Comments for Planning Application DC/21/06683

Address: Grange Farm Drinkstone Road Gedding Suffolk IP30 0QE

Proposal: Planning Application - Conversion of and extension to outbuilding to form annexe for elderly relatives.

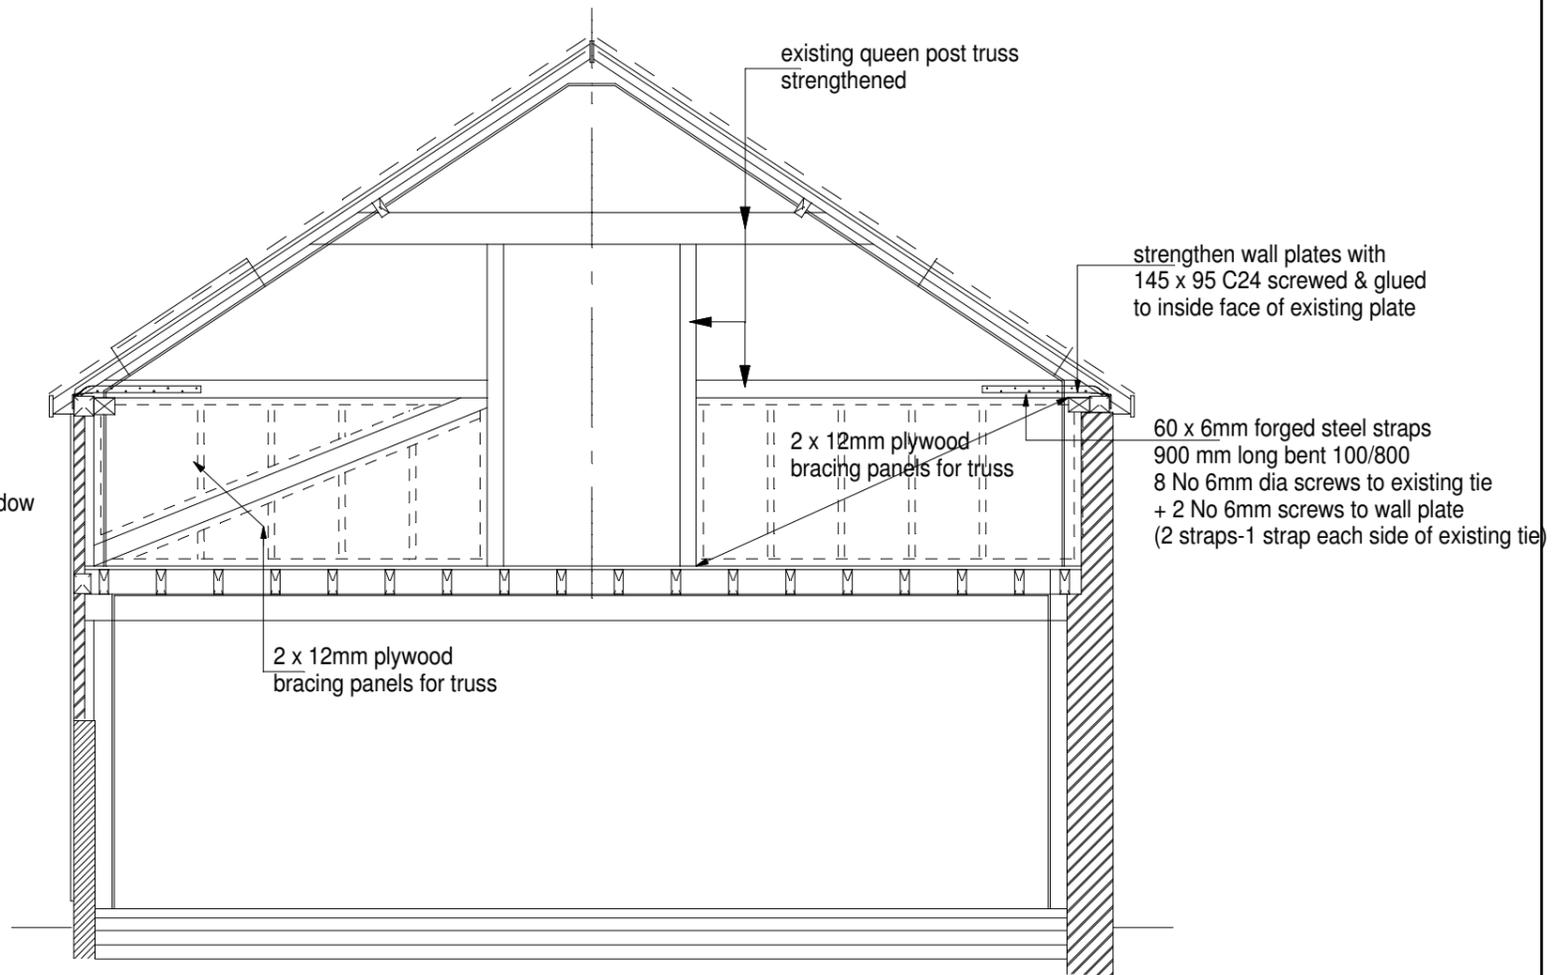
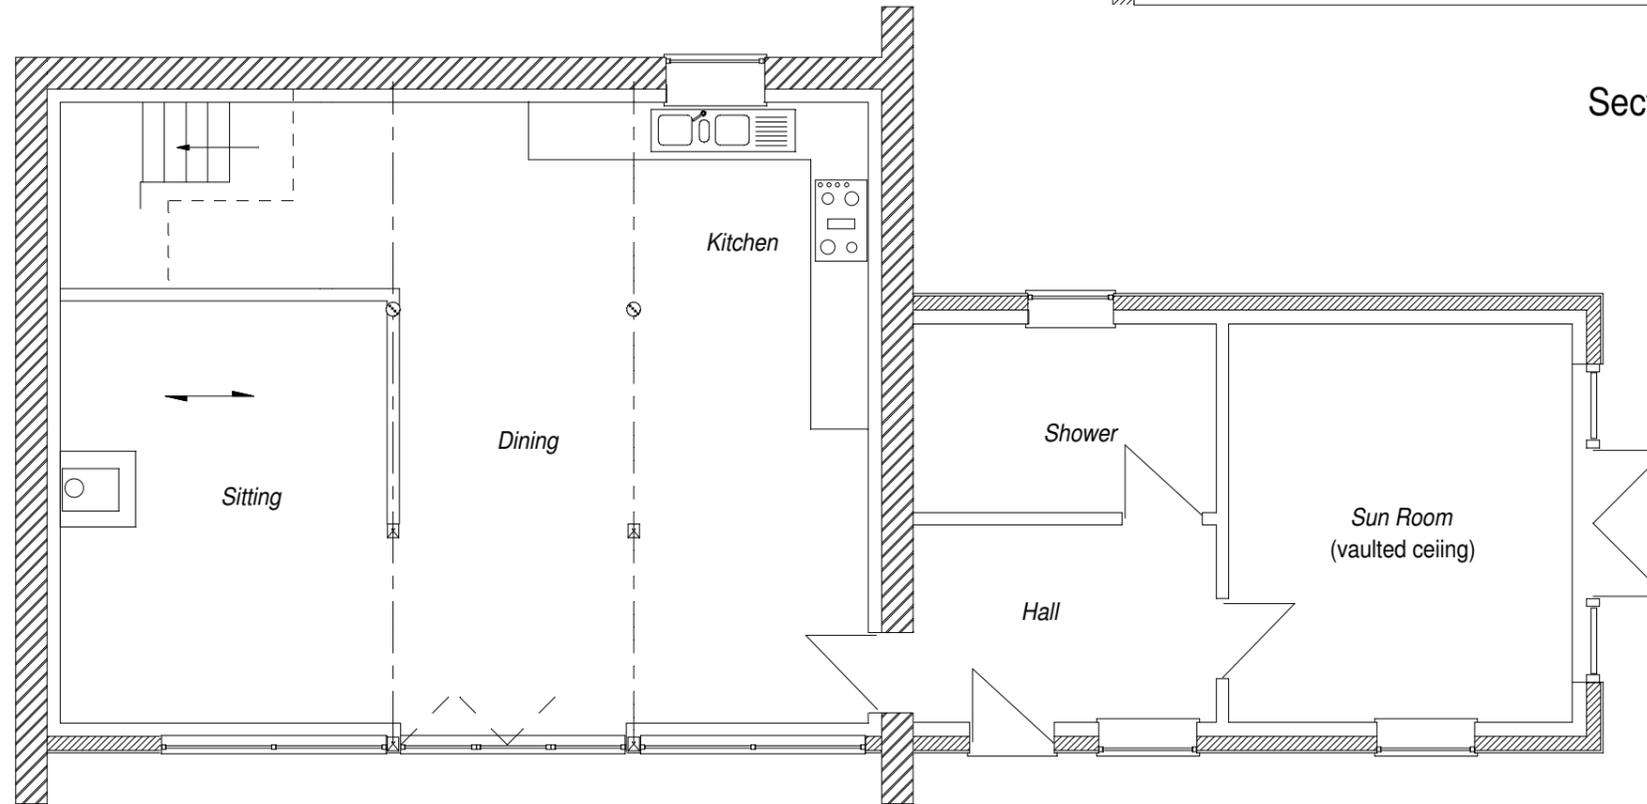
Comment: Privacy is a must for my wife and i and therefore must object to the application due to being over looked by the window/door facing west to be a window. I would have no problem if this was bricked up. I also object to the two velux windows that face south as these look over us, but would have no objection if these were at a height when standing on floor you couldn't see out as mine do facing my neighbour
